SUBJECT: Engineering Review Comment
Mountain View Electric Association Inc. (MVEA)

Project Name: Miles Subdivision – Terra Ridge North Final Plat

Project Number: SF2239

# Final Plat Terra Ridge North

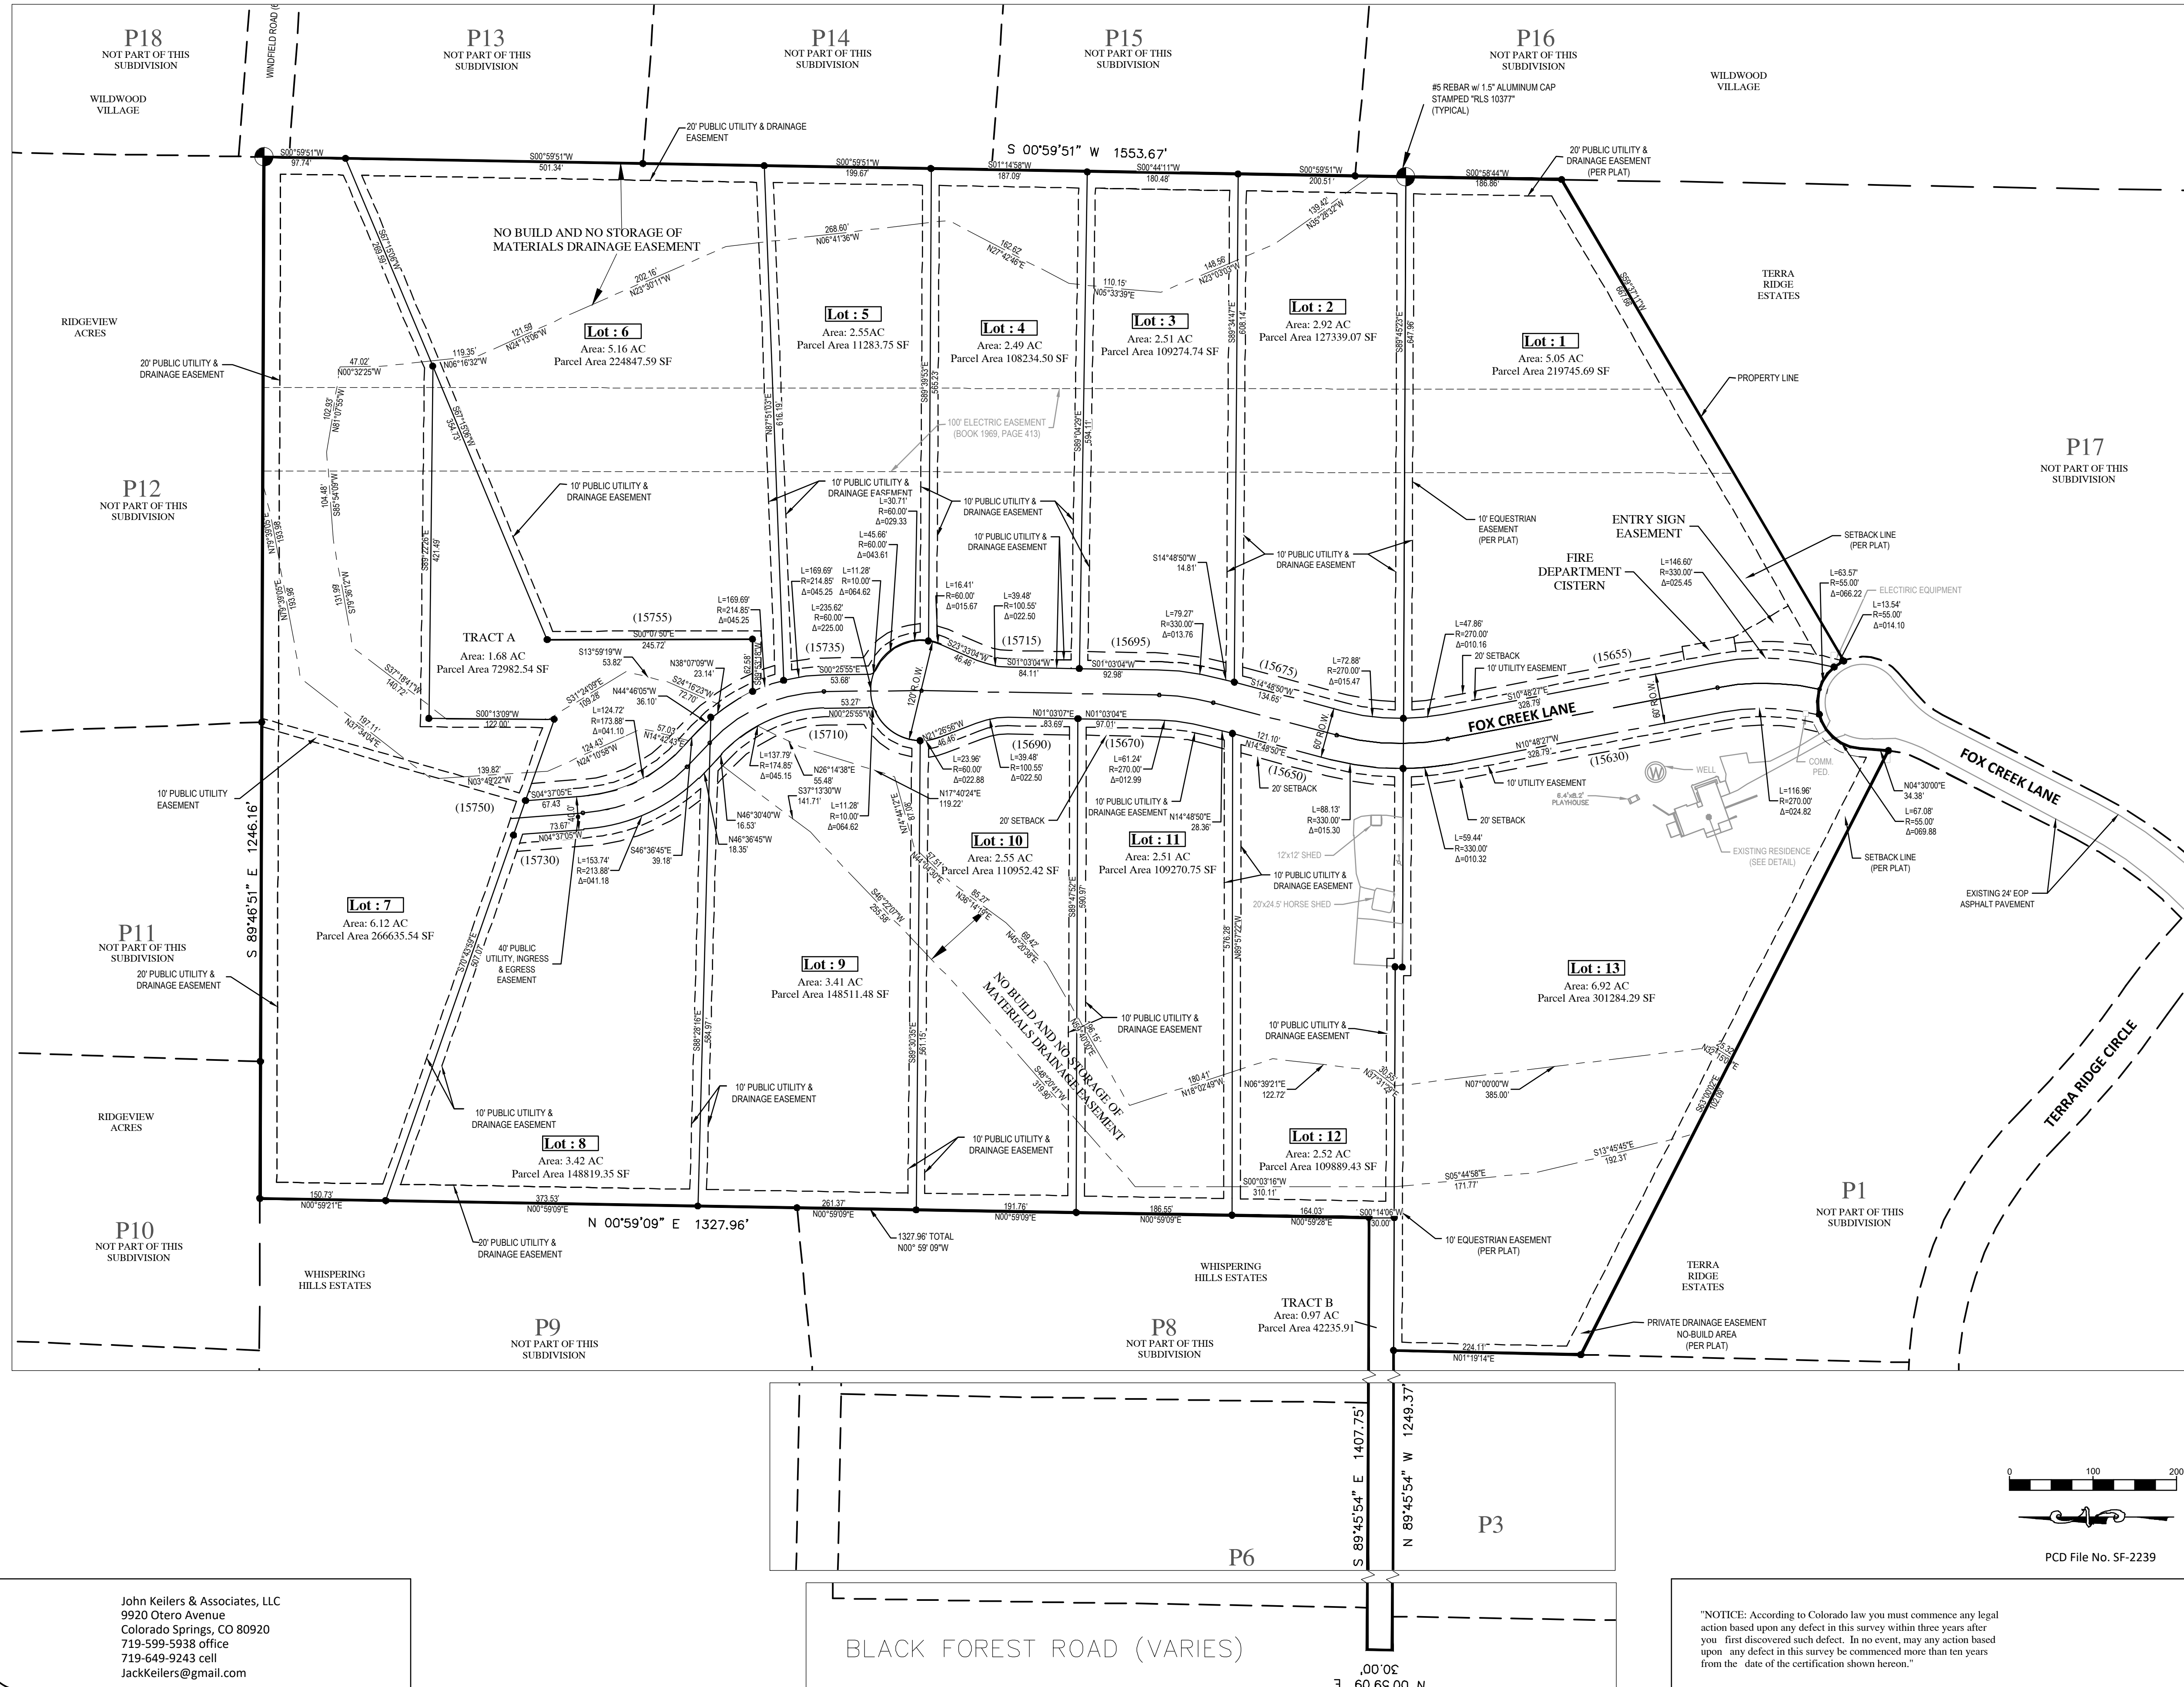
MVEA requests a ten (10) foot front, side, and rear lot utility easements in addition to any public improvement easements. MVEA also requests the platting of MVEA's existing facilities with easements on the plat. Additional easements may be required.
